KITTITAS COUNTY DEPARTMENT OF PUBLIC WORKS

County Survey review of Short Plat 16-00005 Double K

Required Changes for Final Plat:

**DOUBLE K SHORT PLAT**

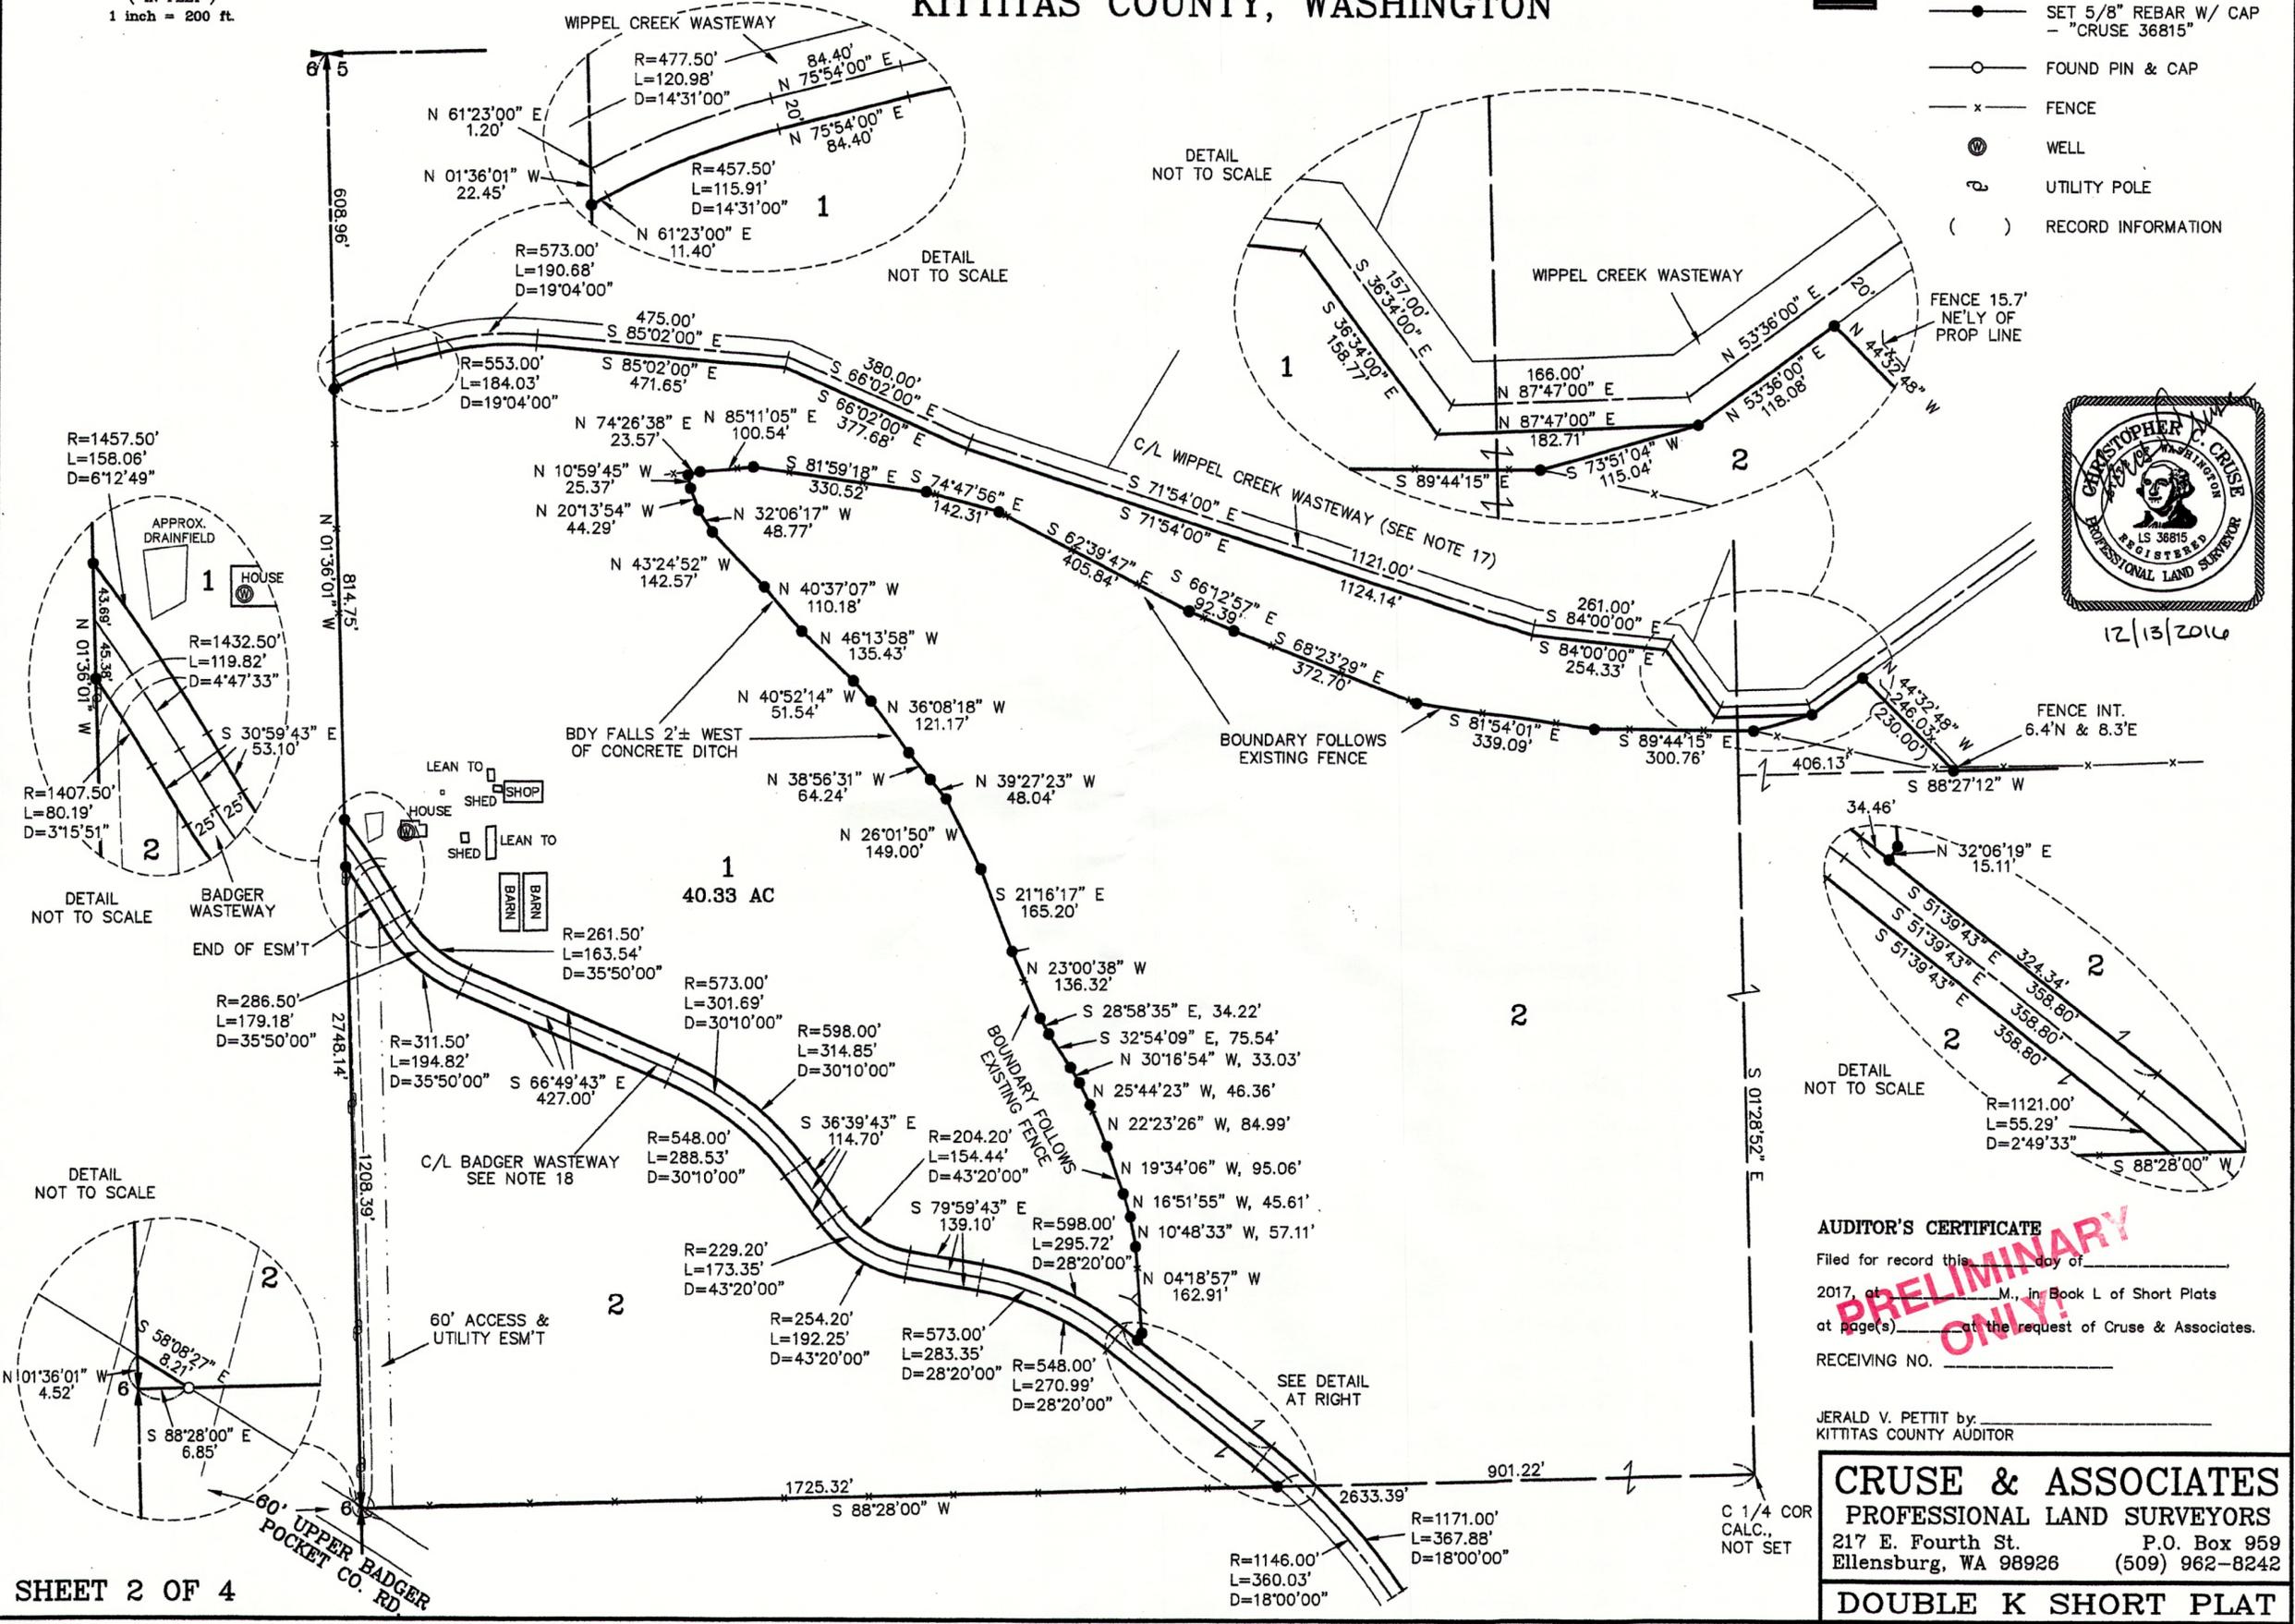
1. The dashed lines adjacent to the West boundary of Section 5, within the 60' Access easement should be identified. It is assumed these lines represent a driveway, but that should be clarified.
2. The 60' Easement adjacent to the West boundary of Section 5 should be labeled as "Existing", "Herein Dedicated", or "Created via separate document". If the first or third option is used, the Auditor's File No. shall be included. It should be noted that the easement as shown does not connect to Badger Pocket Road with the full 60' width.
3. Any submittal which includes contours or elevations shall include a reference to the vertical datum used.
4. The following corrections shall be made to the legal description:
Paragraph 2, Line 5: Southeast corner thereof: And **thence** East...
Paragraph 4, Line 6: to the center section line; thence **North** 89-59...
